**CITY OF PORTLAND, MAINE  
DEVELOPMENT REVIEW APPLICATION  
PLANNING DEPARTMENT PROCESSING FORM  
Planning Copy**

**Boy Scouts, New Building**  
Project Name/Description  
**131 - 131 Johnson Rd, Portland, Maine**  
Address of Proposed Site  
**232 A005001**  
Assessor's Reference: Chart-Block-Lot

**From:** Jeffrey Preble <jpreble@dufresne-henry.com>  
**To:** "jspence@ci.portland.me.us" <jspence@ci.portland...>  
**Date:** Sun, Jul 8, 2001 10:27 AM  
**Subject:** Boy Scout Review

**TO:** Chair Caron and Members of the Portland Planning Board  
**FROM:** Jonathan Spence, Planner  
**DATE:** July 10, 2001  
**SUBJECT:** Boy Scouts of America, Pine Tree Council Headquarters, 131 Johnson Road

CONCEPTUAL WALL DETAIL
N.T.S.

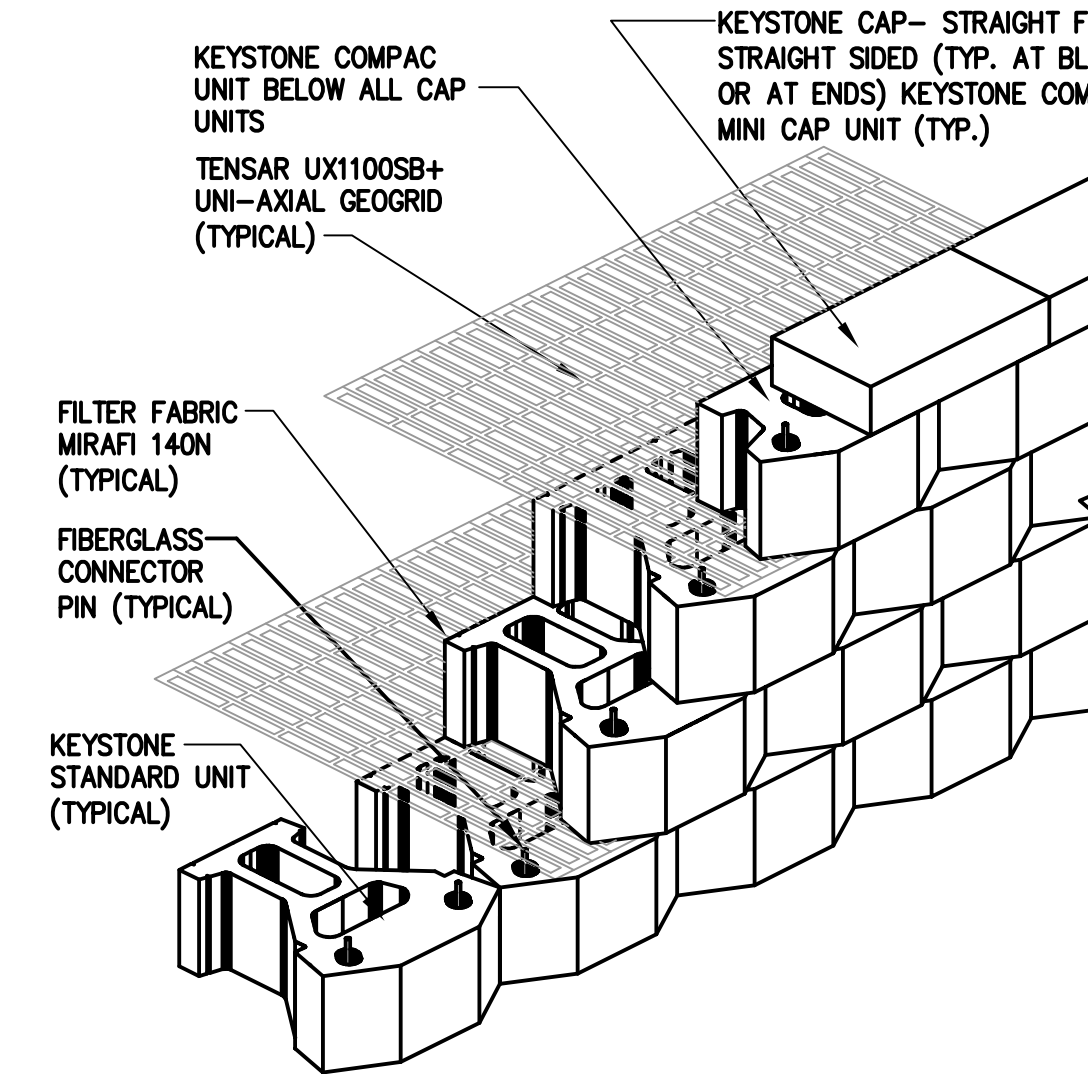
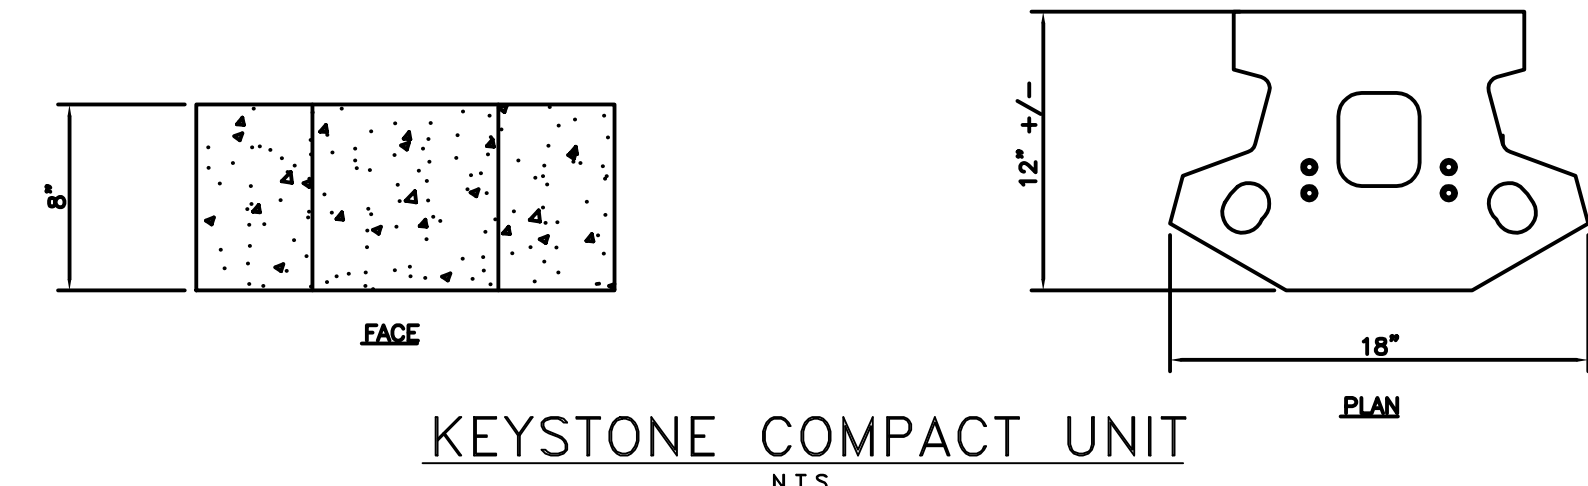
The preliminary granite wall detail is missing from our information.
